Ref: D2016/64908

8 June 2016

**Proposed Dangerous Goods Facility, Warehouse 3B (SSD 7491)
Response to Exhibition of EIS**

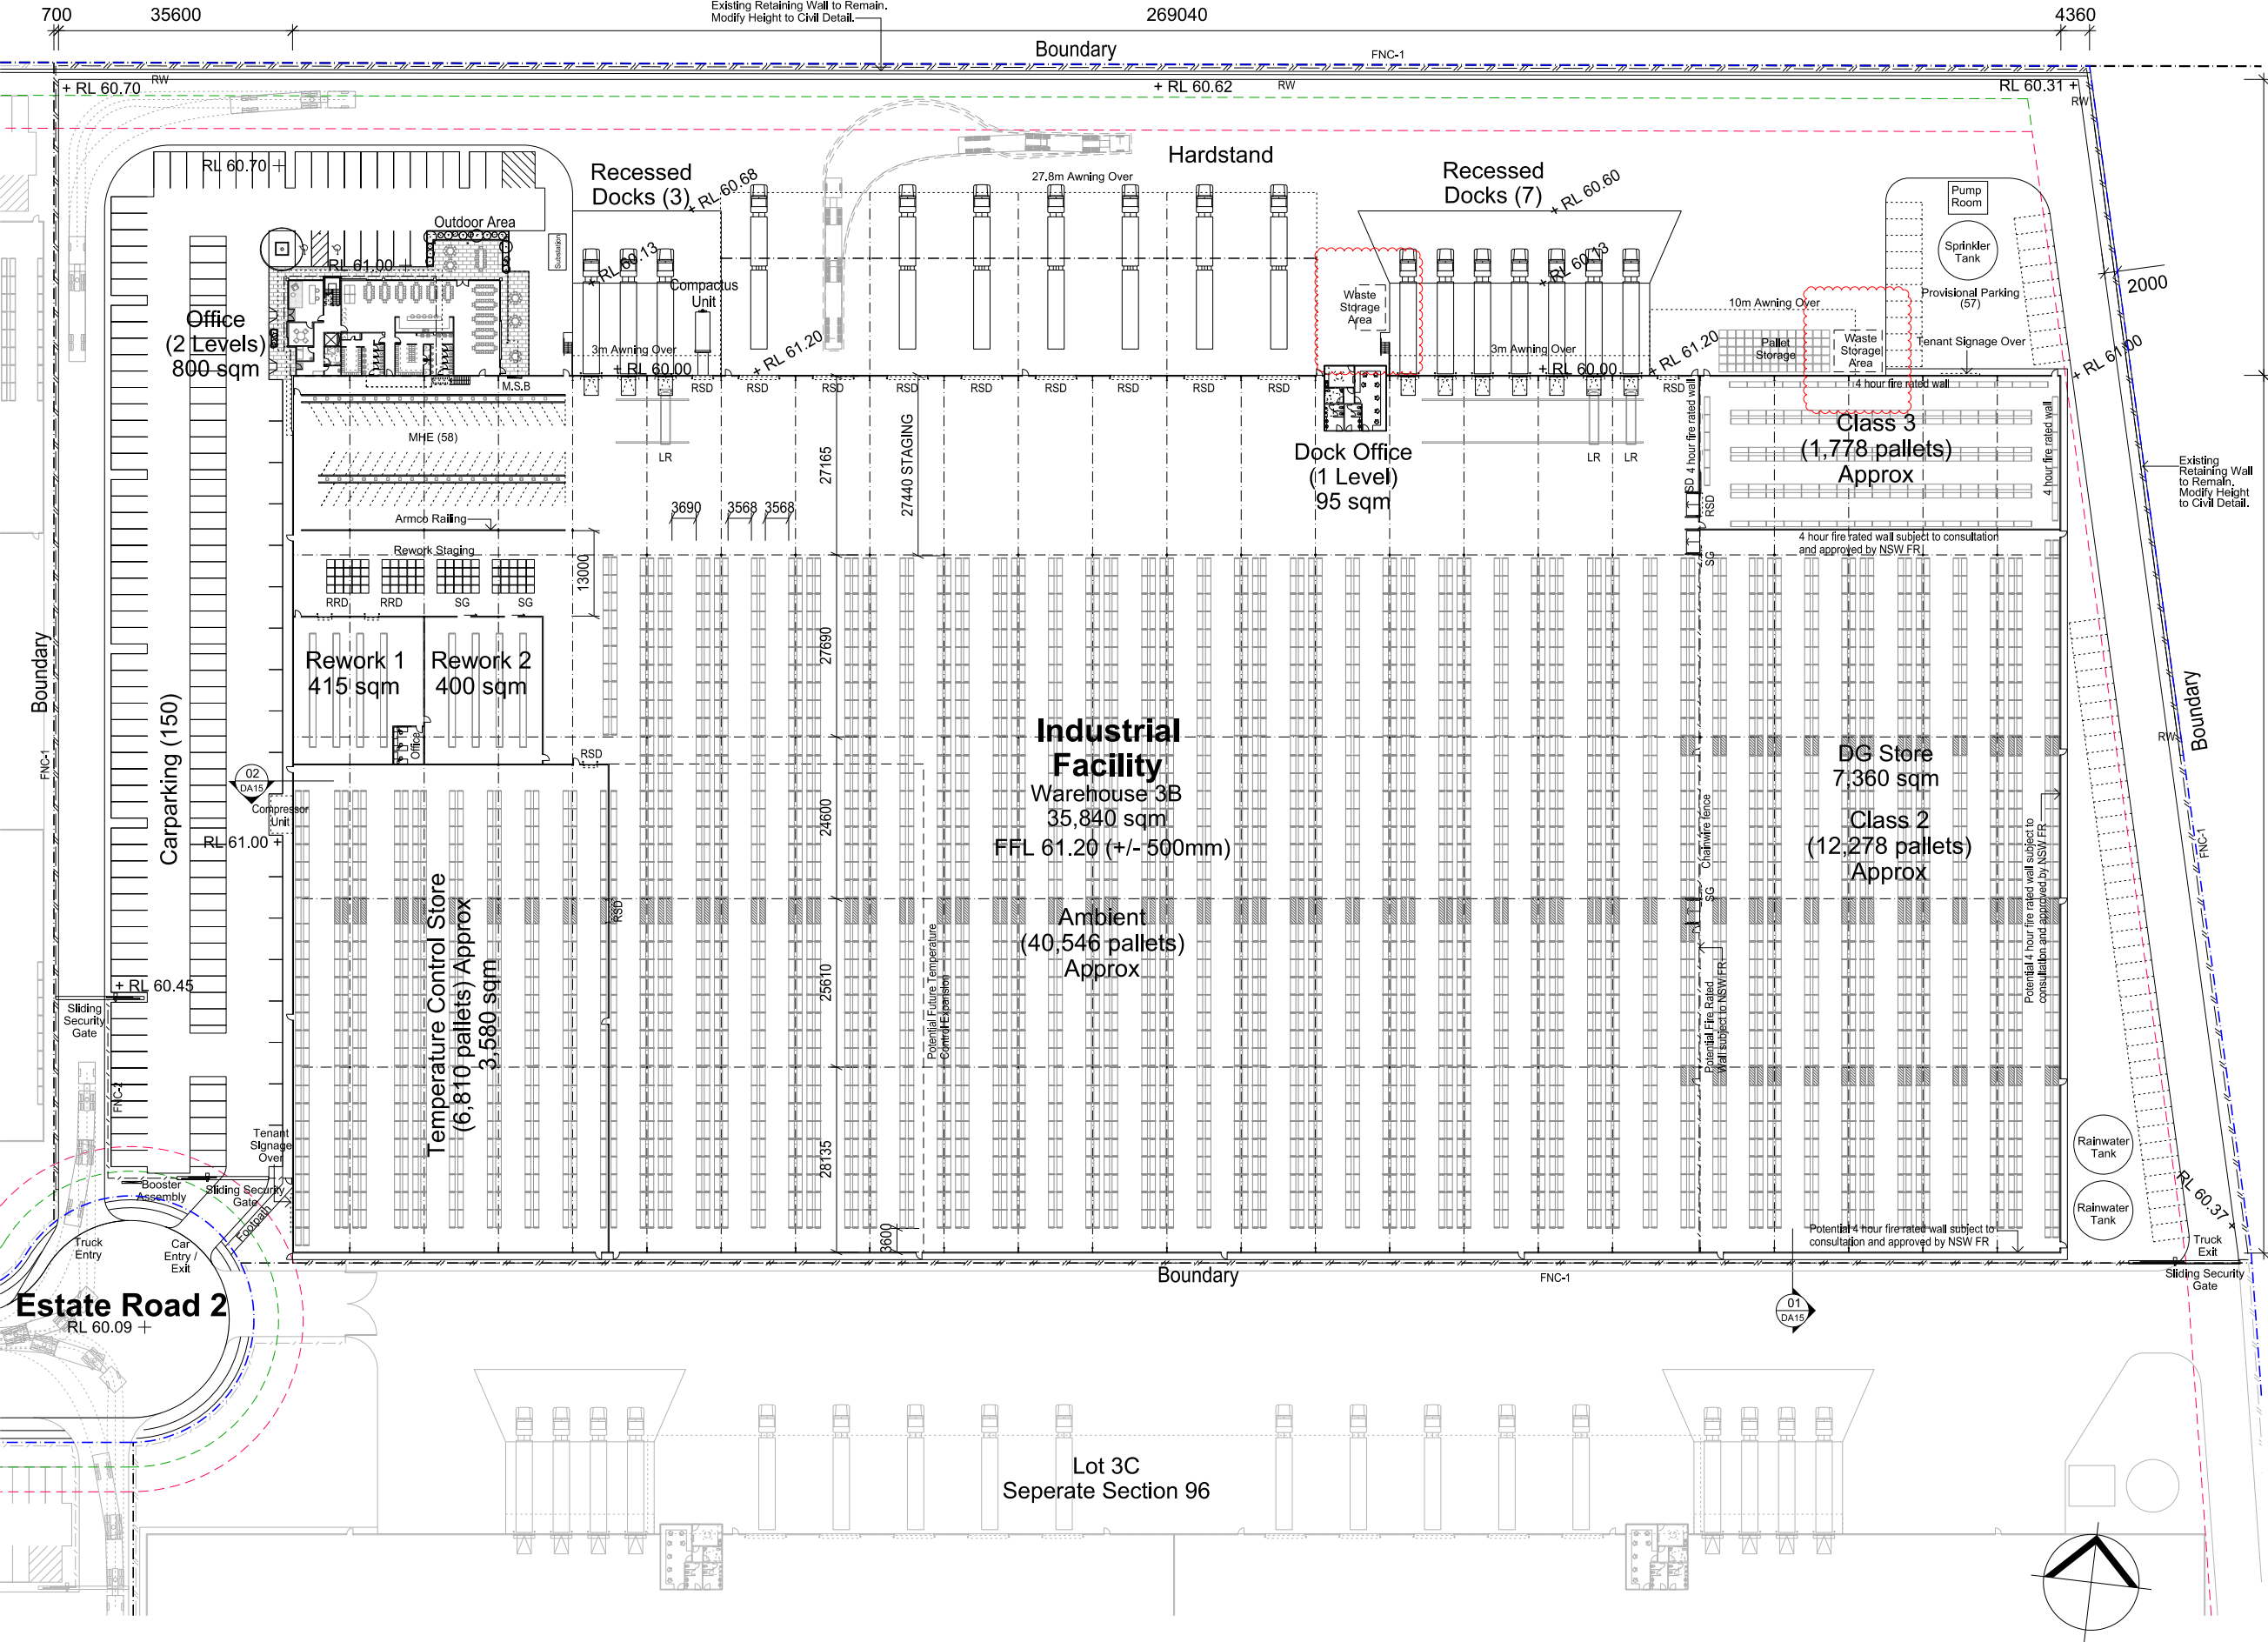
It is noted that a swept path analysis of the proposed access and internal roads has been undertaken as part of the Traffic Report. This analysis and report lacks information as to the risk of damage to WaterNSW's pipelines from potential vehicle accidents, and the associated transportation of dangerous goods, particularly as the top of the building platform will be directly adjacent to and higher than No.1 Pipeline.

This is particularly an issue at the north western area of the site with vehicles travelling around the corner from the access road to the service bays. In addition there is no clarification that the traffic collision guards and fencing would suitably protect the pipelines in this instance. We request that the proponent consults with WaterNSW in the final design of the traffic collision guards.

The EIS does not make clear the reason for increasing the height of the retaining walls adjacent to the site boundary with the pipelines from between 0.6 and 0.8m. During the construction of the retaining walls there is a risk of accidental damage to WaterNSW's pipelines adjacent to the site.

It is noted in the Civil Plans (Appendix 5) that chain wire boundary fencing is proposed along the common boundary of the site and the pipeline corridor. Security fencing is required to minimize the potential for the public to access the pipelines and the associated corridor. This fencing should be constructed to WaterNSW standards at 2.1 meters high, of chain mesh and with 3 strand barbed wire in addition, and installed along the entire length of the boundary of the Pipeline corridor and the development site.

Water NSW requests that the proponent is required to:

- implement all practical measures to prevent damage to WaterNSW's water supply infrastructure that may result from the construction or operation of the project
- install temporary traffic barriers during construction wherever construction activities are undertaken immediately adjacent to the Pipelines corridors
- repair, or pay all reasonable costs associated with repairing WaterNSW infrastructure that is damaged by the project.
